From: Morag Hoppe [REDACTED]
Sent: 13 September 2020
To: Amber Willard
Subject: FP/194/21/HH - 3 CULVER ROAD, FELPHAM

I am writing regarding the householder application recently submitted for 3 Culver Road.

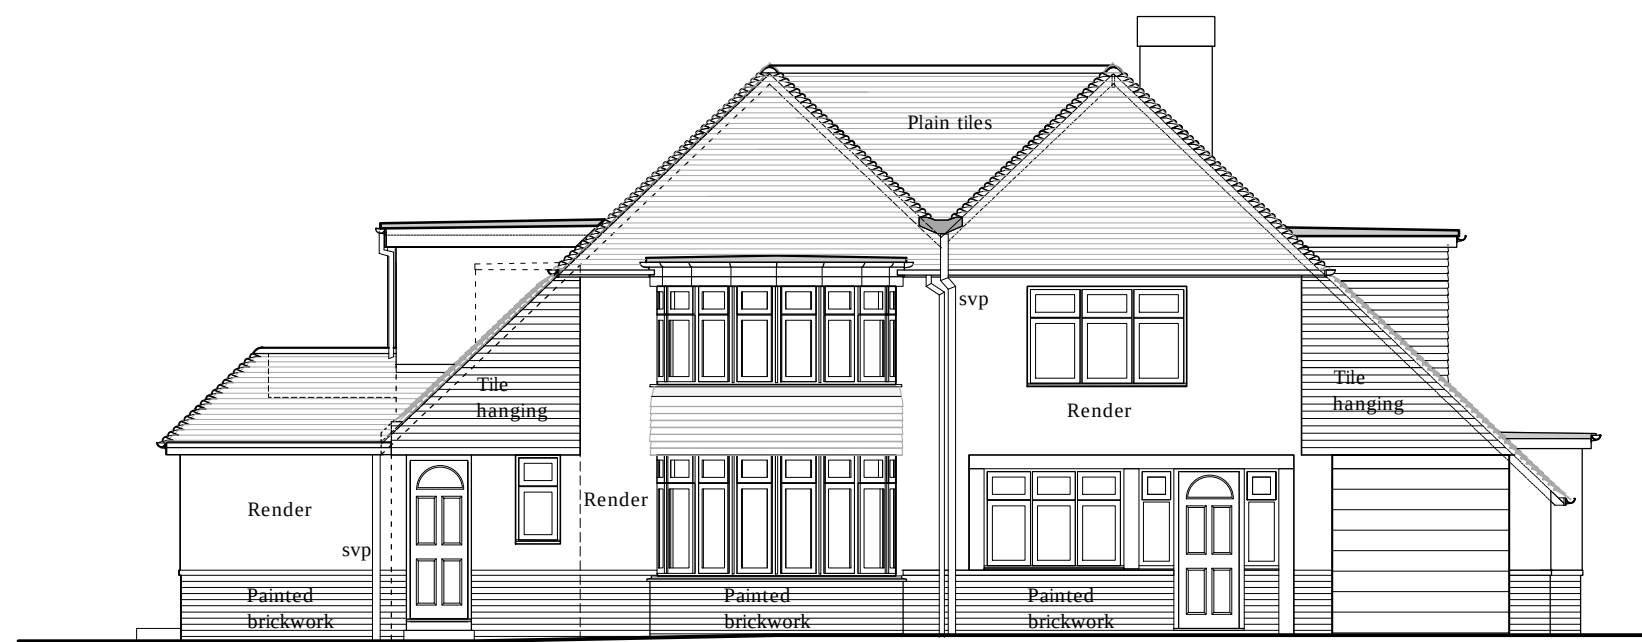
Our client (the applicant) Mr Buckley has asked me to notify you that the proposed colour for the new bi-fold doors in the extension is anthracite grey and not white.
